DECISION DELEGATED TO HEAD OF PLANNING

Application No: H05-0634-23 **Applicant:** Y Ward
Proposal: Extension & Alterations
Location: 34 East Gate Fleet Hargate Spalding
Terminal Date: 22nd September 2023

CASE OFFICER ASSESSMENT

Drawing	Y. WARD
FLOOR PLAN - EXISTING & PROPOSED ELEVATIONS - EXISTING & PROPOSED SITE & LOCATION PLANS	
Job Ref.	Drawing No.
4155-25	013
Date	Drawn
JUNE 2025	SLB

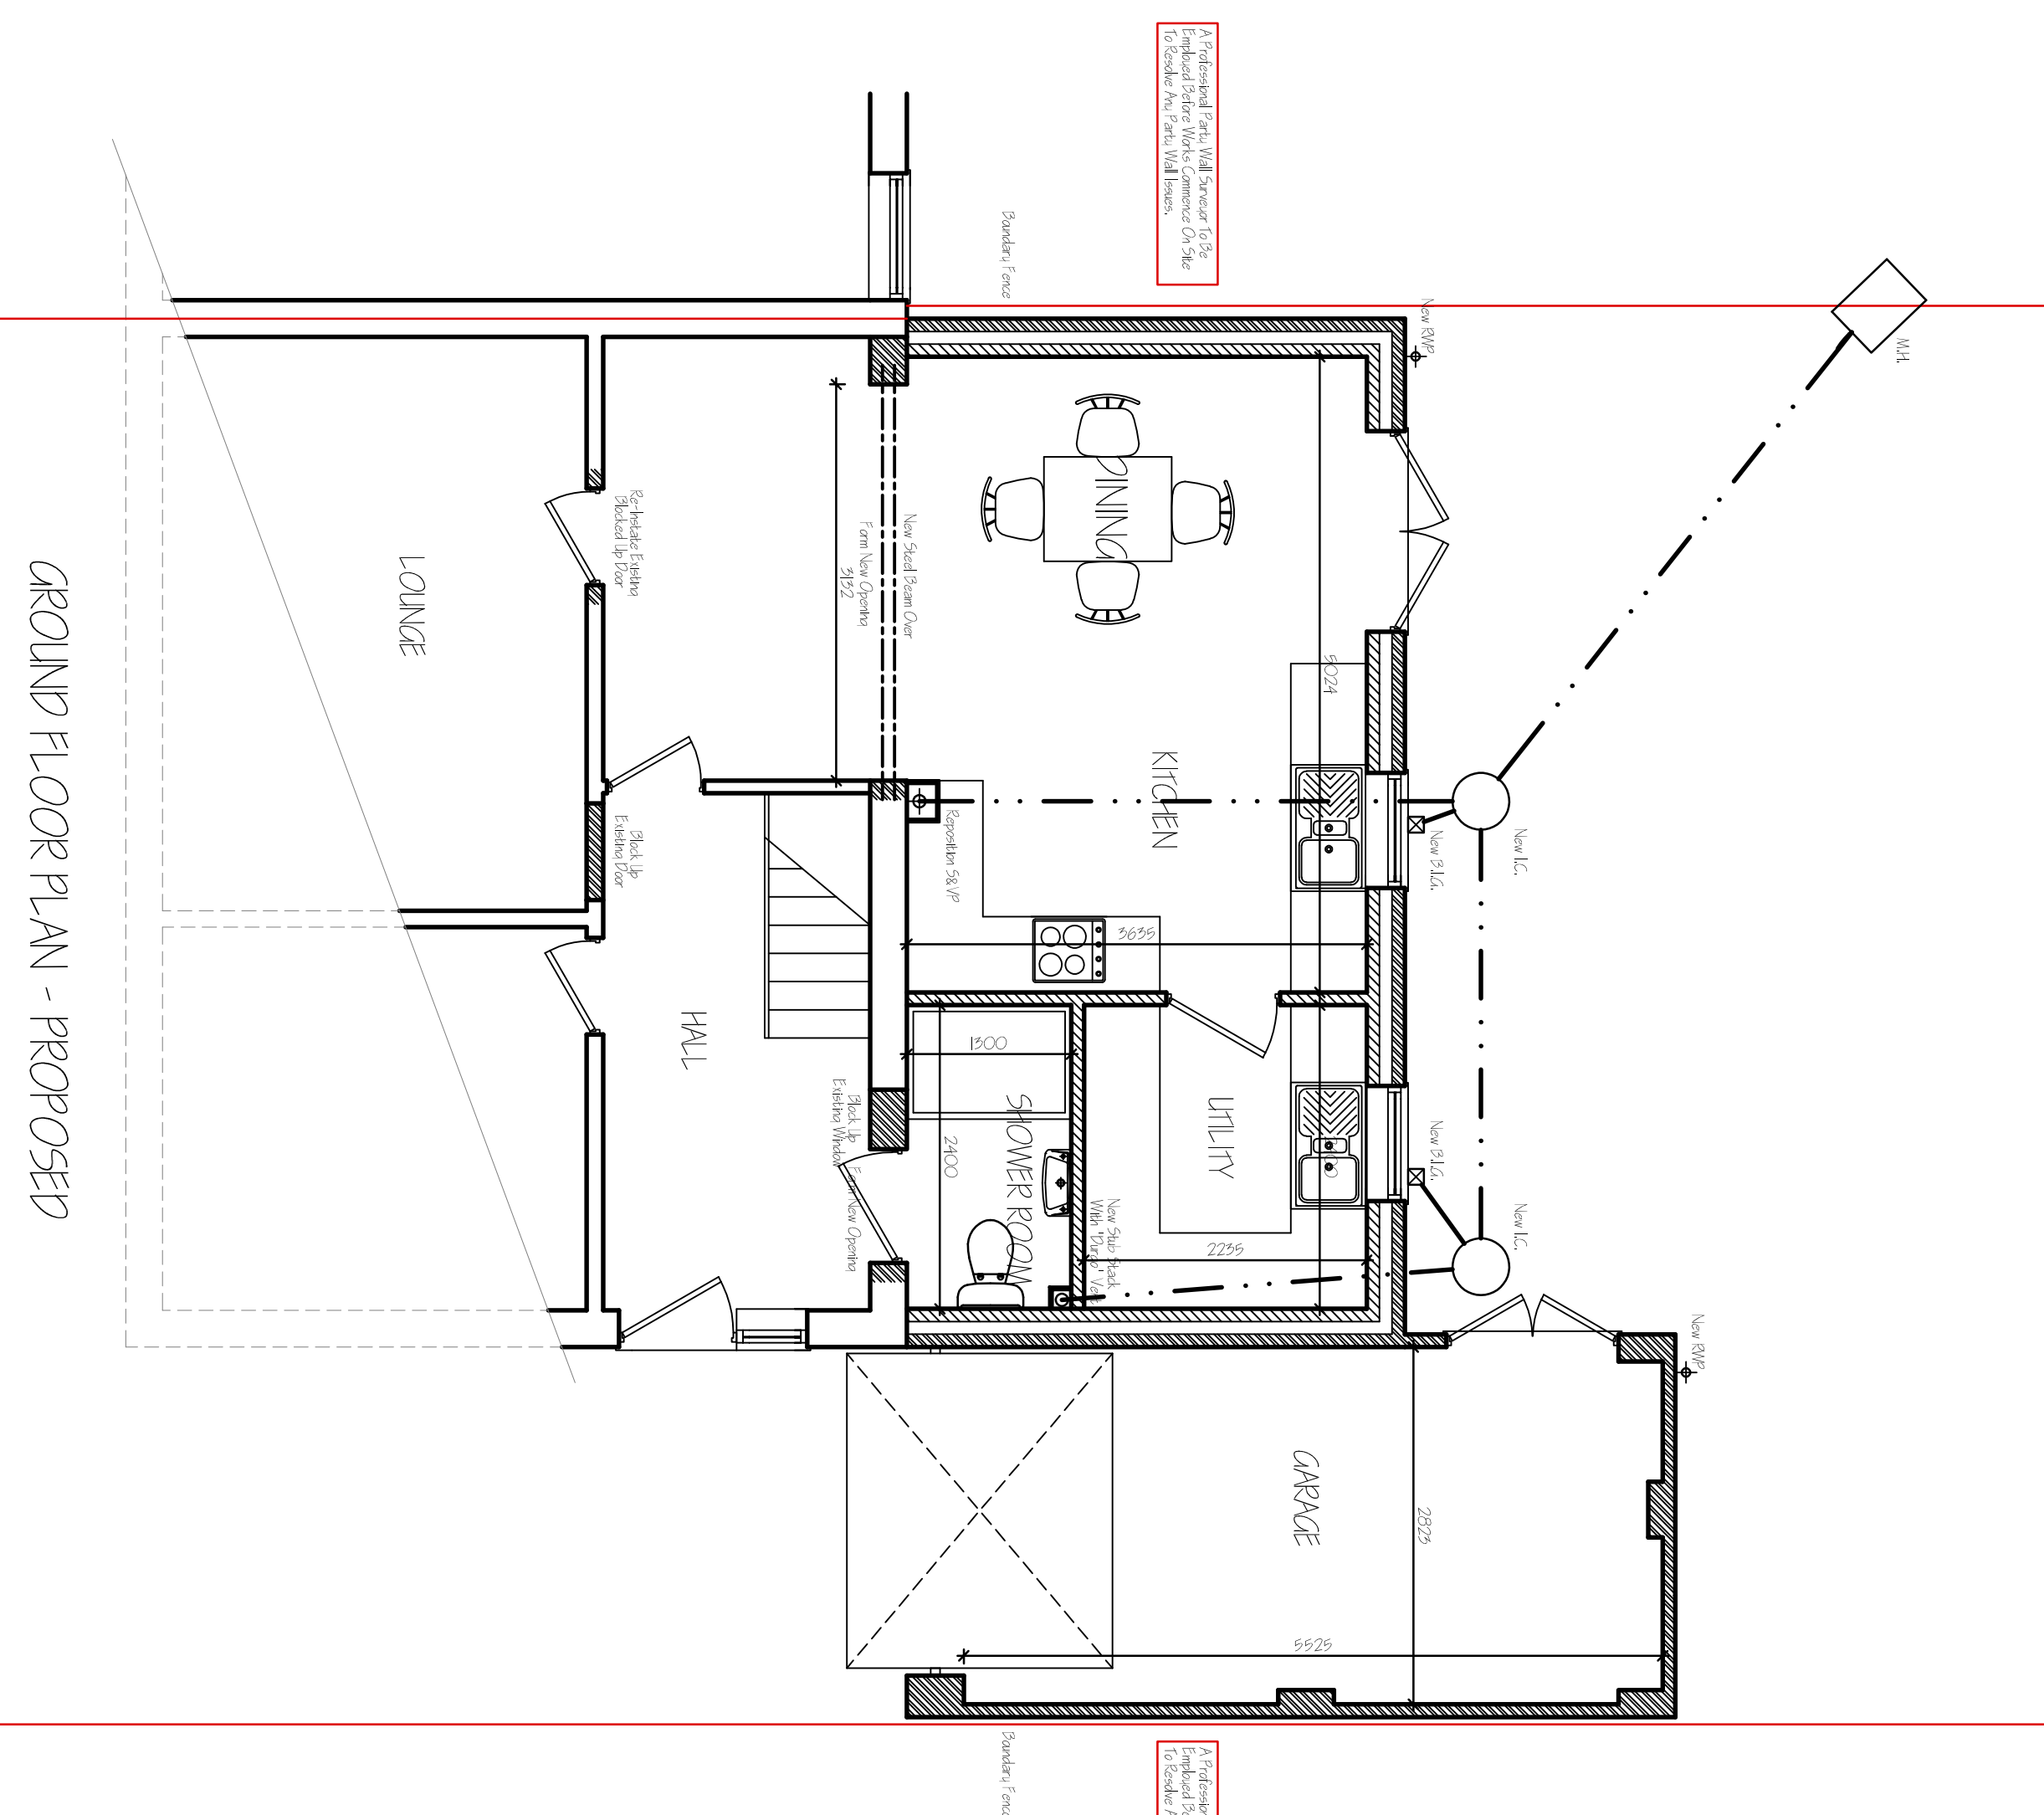
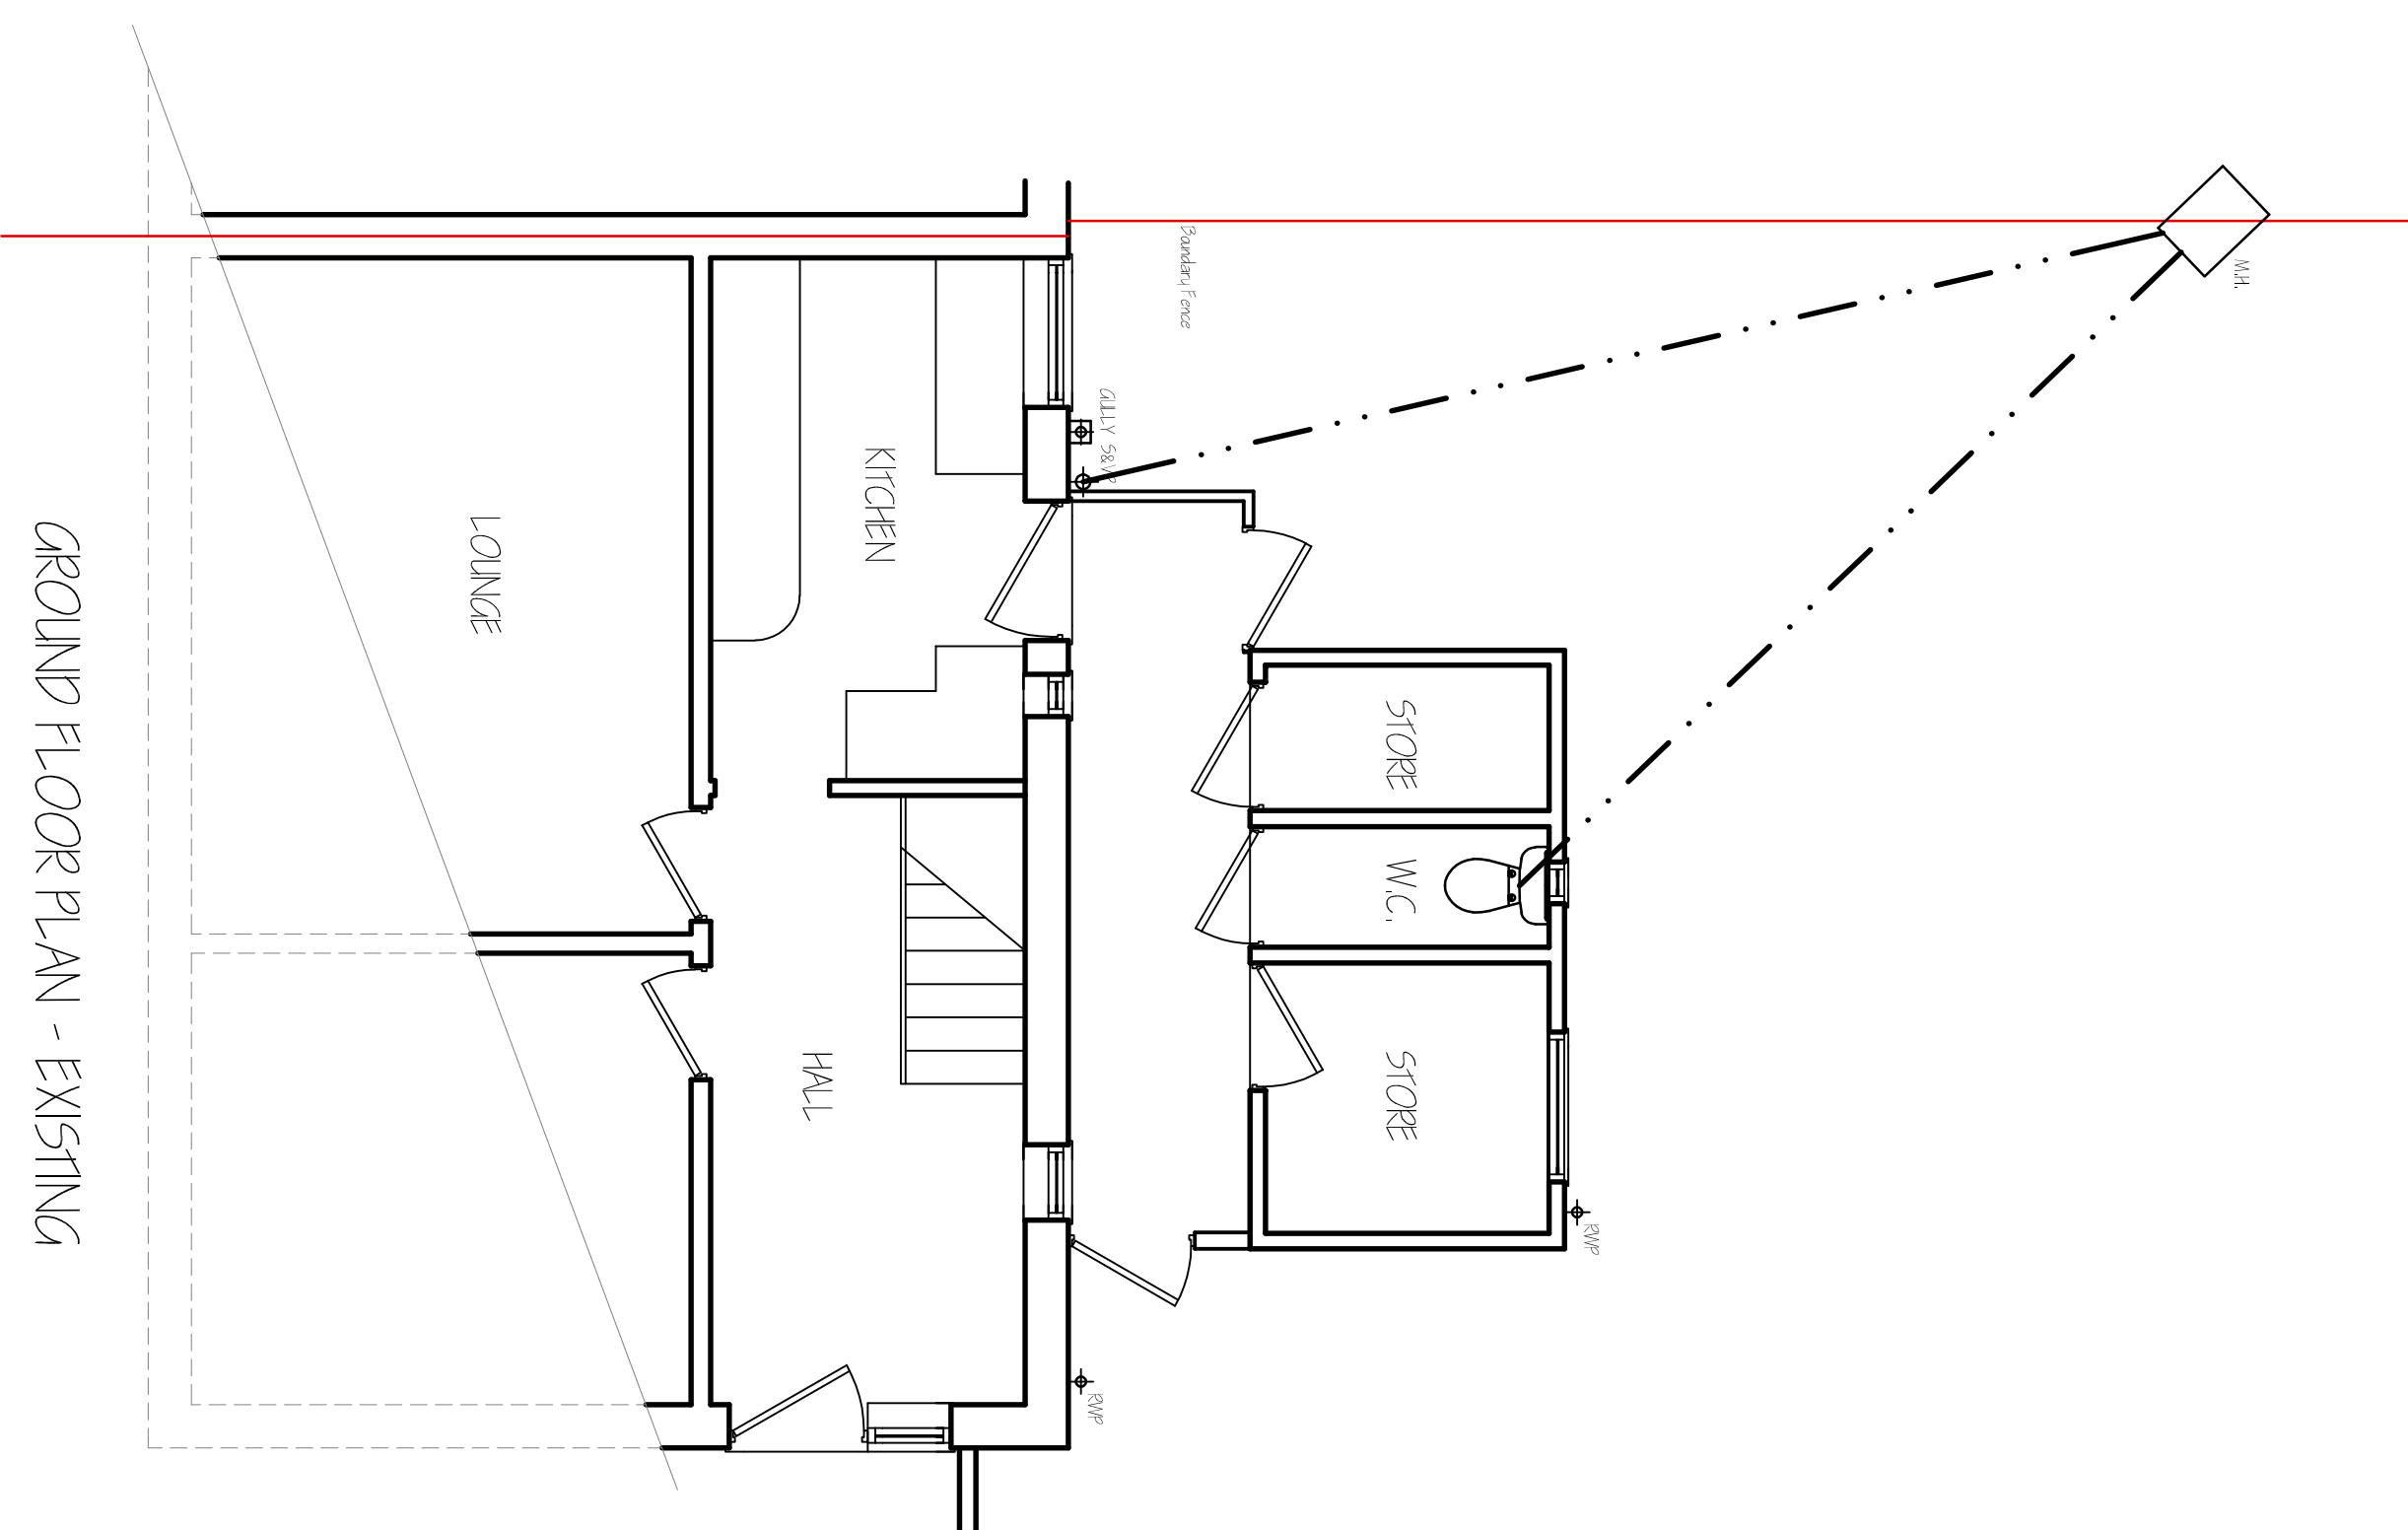
The materials for the walls, windows and doors will all match that of the existing dwelling and therefore ensures that it will blend in and not create any visual discrepancies. The design of the roof is flat, flat roofs are not commonly favourable by LPA's and due to the sheer size of this proposed extension it is not considered to be acceptable and therefore conflicts with Policy 2 & 3. It is not uncommon for the dwellings in this area to have single garages however the majority of the semi-detached properties do not feature one, the garage will provide more floor space alongside the extension as well as an area to store things and provides another parking space as it meets the requirements. The proposed garage is also therefore considered acceptable.

The extension will protrude from the rear by 3635mm and will be the full length of the house (7434mm), the new garage will be 2823mm by 5525mm. The proposal incorporates a new shower room (2400mm x 1300mm), utility (2400mm x 2235mm) and a kitchen (5024mm x 3635mm). The measurements of the extension and garage are considered to be acceptable when compared to the main dwelling and will provide adequate extra floor space.

There is a distance of 0.3m between the north east elevation and the neighbouring boundary on this side and is on the boundary of the south west side. The development is considered to cause a loss of light onto the neighbouring property due to it being a large development right on the boundary. No. 36 shares its boundary with the host site due to its semi-detached nature, following the case

officers further investigation to the site it appears that the window that will suffer the most is a kitchen window, a habitable room which would significantly suffer from this loss of light that would occur. As such the minimal distance between the proposal and the boundaries/curtilage is a significant issue and therefore directly conflicts with Policy 2 & 3 of the SELLP and Section 12 of the NPPF.

When compared to the existing rear section that will be demolished the proposed rear extension is significantly bigger in terms of floor space and area, the existing has a total floor space of approximately 14 metres squared where as the proposed has 32 square metres for the main part and then 18 metres squared for the garage (approx. 50 metres squared in total). Based on this measurements it is clear that the overall size will increase significantly and therefore it will appear overbearing on the neighbouring property due to the size and scale of the extension. As mentioned before it will be a large development close to the boundaries and will appear as a cramped form of development.

The proposal is considered to conflicts with Policies 2 & 3 of the SELLP and Section 12 of the NPPF in relation to the design with the flat roof and the potential for it to be overbearing and overshadowing onto the neighbours. The concerns raised by the neighbours in relation to boundaries has been solved as it is not the responsibility of the LPA to be involved in this and the drains appear fine from the correspondence with the agent and the consultation response from Anglian Water. The planning balance is therefore against the application.
